## Appeal Decision

**Appeal Ref: APP/R5510/D/24/3336733**

**54 Dale Drive, Hayes, UB4 8AH**

- The appeal is made under section 78 of the Town and Country Planning Act 1990 against a refusal to grant planning permission.
- The appeal is made by Mr Hayet Ullah against the decision of the Council of the London Borough of Hillingdon.
- The application Ref 5861/APP/2023/1784, dated 20 June 2023, was refused by notice dated 3 November 2023.
- The development proposed is hip to gable roof conversion with rear dormer.

PROPOSED FRONT ELEVATION
SCALE 1:100

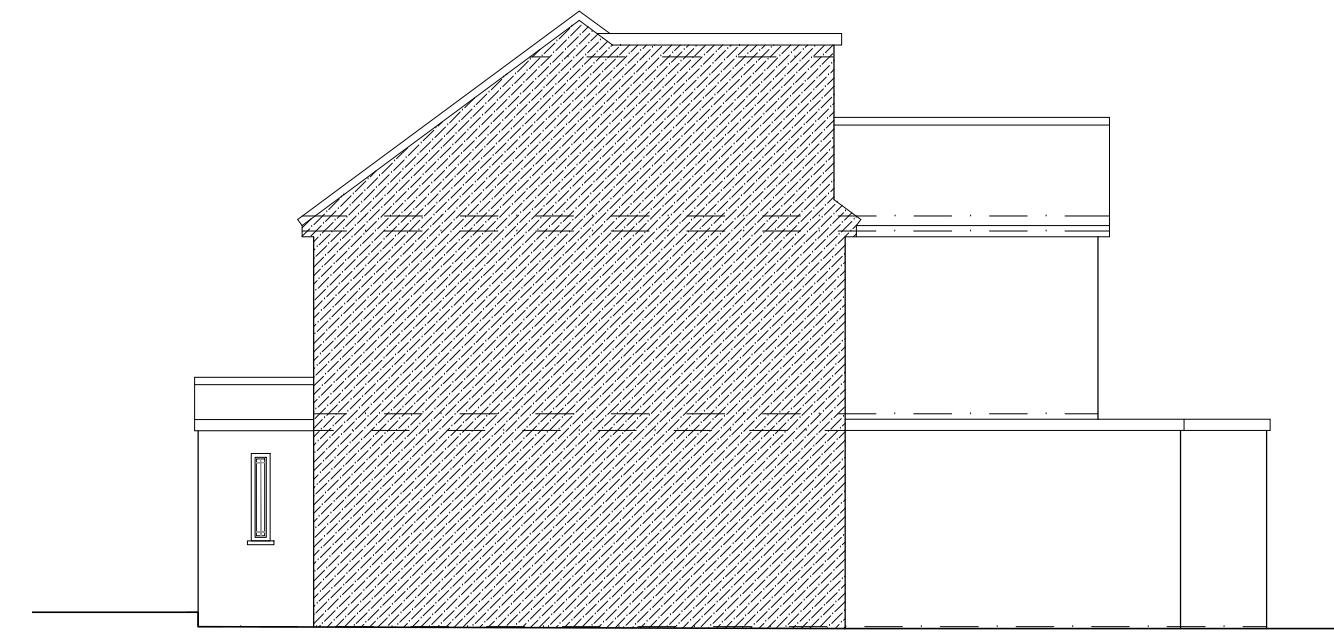
5. The changes proposed at the front would be apparent in limited views in the public realm. In this regard the most marked feature would be the introduction of a gable replacing the hip in the main, original roof of the property. However,

when approaching down the street from the north-east, views of the roof would be largely masked by extant property. In views closer to the property, the relatively low pitch of the roof means that the gable would not prove intrusive, and the visual effect of its introduction would be offset by the use of matching materials and the retention of the hip on the substantial, previously permitted two storey side extension.

PROPOSED REAR ELEVATION
SCALE 1:100

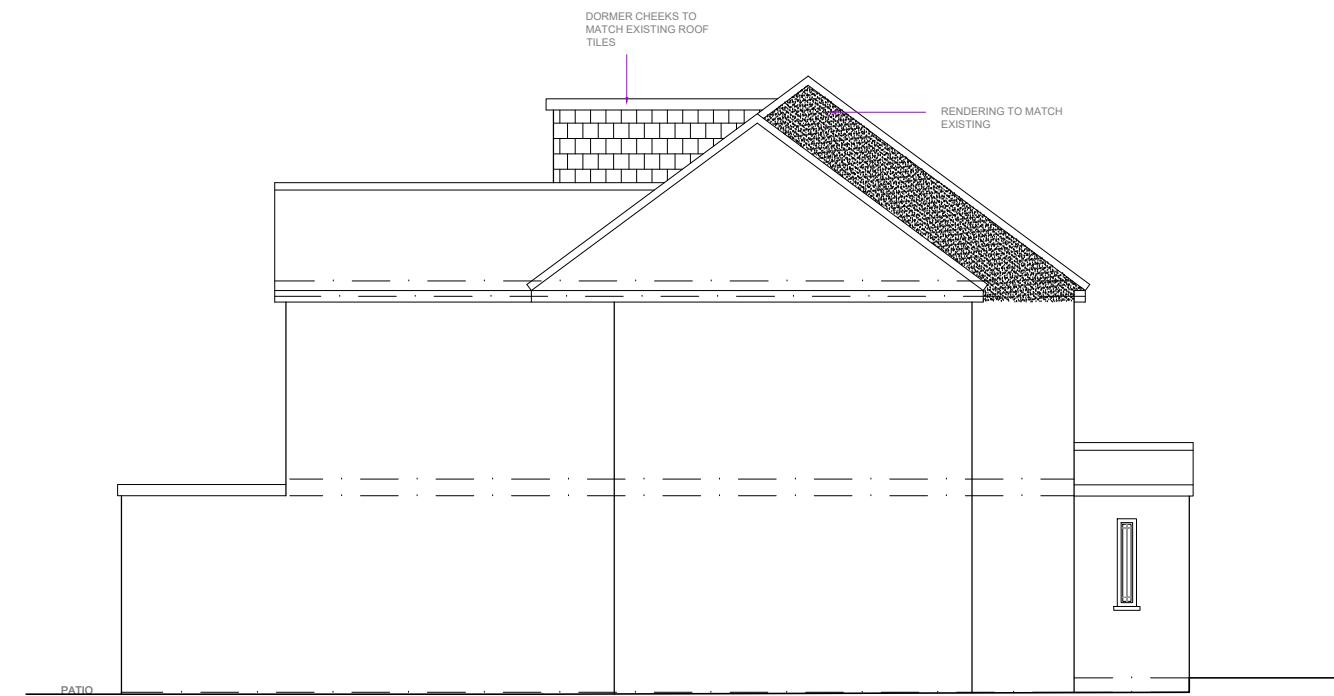
4. As the Council's officer report says, the dwelling has been expanded to a considerable size, but that which has taken place at the rear, given its relatively secluded position, is unobtrusive. The proposal would alter the shape of the roof, but at the rear this would not be dissimilar to that which has taken place on the adjoining property<sup>2</sup>. In any event, the dormer would not be widely seen at the rear and to my mind would not cause offence.
